DRB Application No.: 09DRB-70175 Project # 1007679  
 Project Name: Northern Addition  
 Agent: Lisa & Dan Tortaco Phone No.: \_\_\_\_\_

**DRB Comments**

**RE: Lots 3-5, Block 4, Northern Addition**

DEVELOPMENT REVIEW BOARD – SPEED MEMO

**PLAT OF
LOTS 4-A AND 5-A, BLOCK 4
NORTHERN ADDITION**
WITHIN
TOWN OF ALBUQUERQUE GRANT
PROJECTED SECTION 17, TOWNSHIP 3 NORTH, RANGE 10 EAST, N.M.P.M.
CITY OF ALBUQUERQUE
BERNALILLO COUNTY, NEW MEXICO
APRIL, 2009

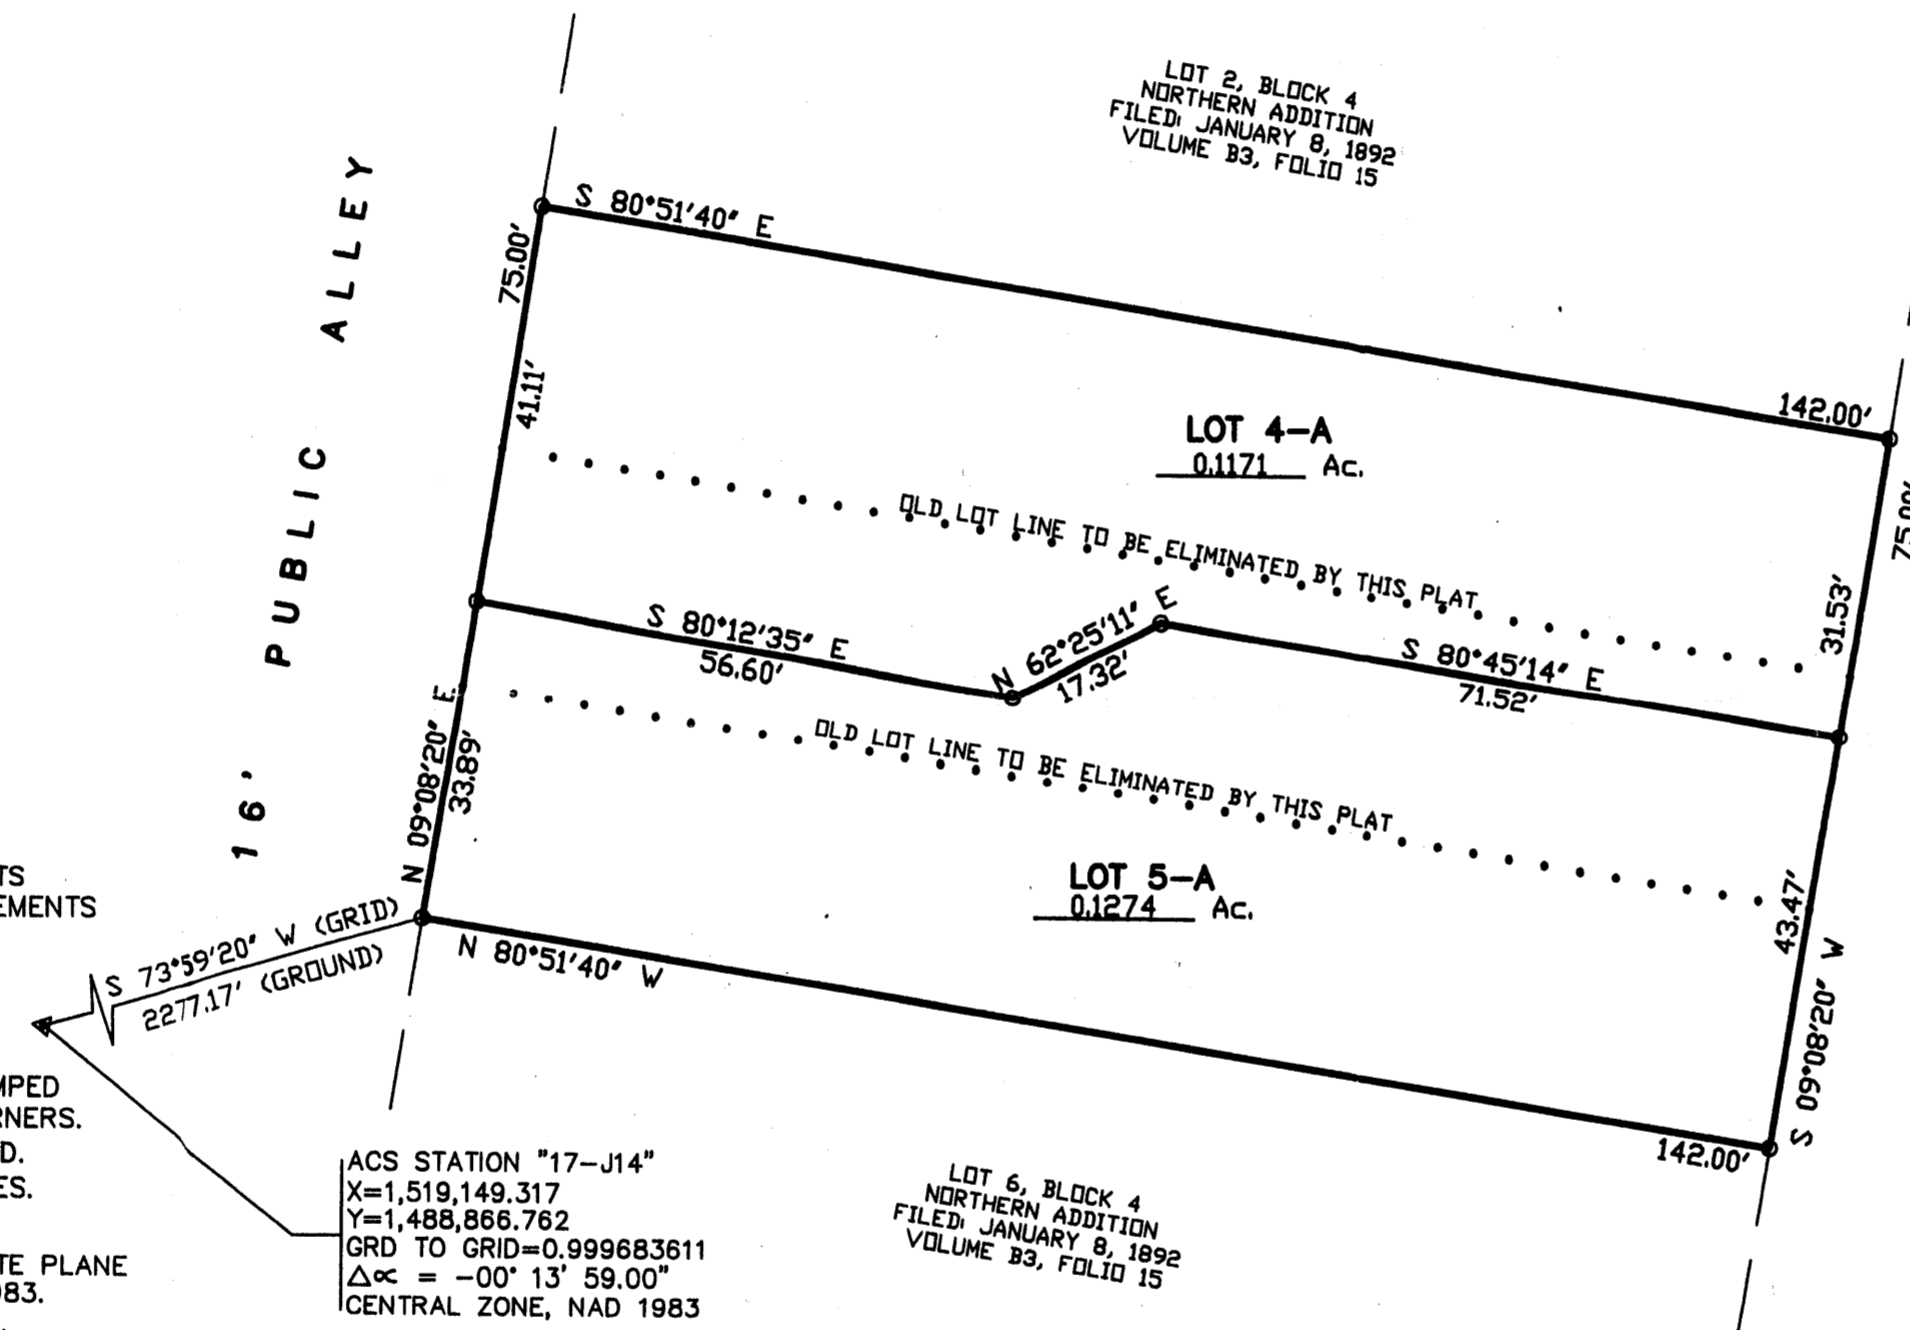
TRANSPORTATION: Adequate R.O.W / Easement for 2nd St

MICHAEL EAVES agent(s) for LA CASTILLA, LLC request(s) the above action(s) for all or a portion of Lot(s) 154C, zoned R-1, located on GUADALUPE TR NW BETWEEN MONTANO AND GRIEGOS NW containing approximately 0.705 acre(s). (F-14) **PRELIMINARY PLAT WAS APPROVED. FINAL PLAT WAS INDEFINITELY DEFERRED. CONDITION OF FINAL PLAT IS VERFICATION OF ACCESS EASEMENT TO GUADALUPE TRAIL AND NET LOT AREA CALLED OUT ON PLAT.**

The storage building at the rear of the property would need to be fully on one lot if it is to remain.

Provide an exhibit showing the location of sidewalk and defining the distance from face of curb to the property line. Right of way dedication may be required.  
Is access taken off of the alley?
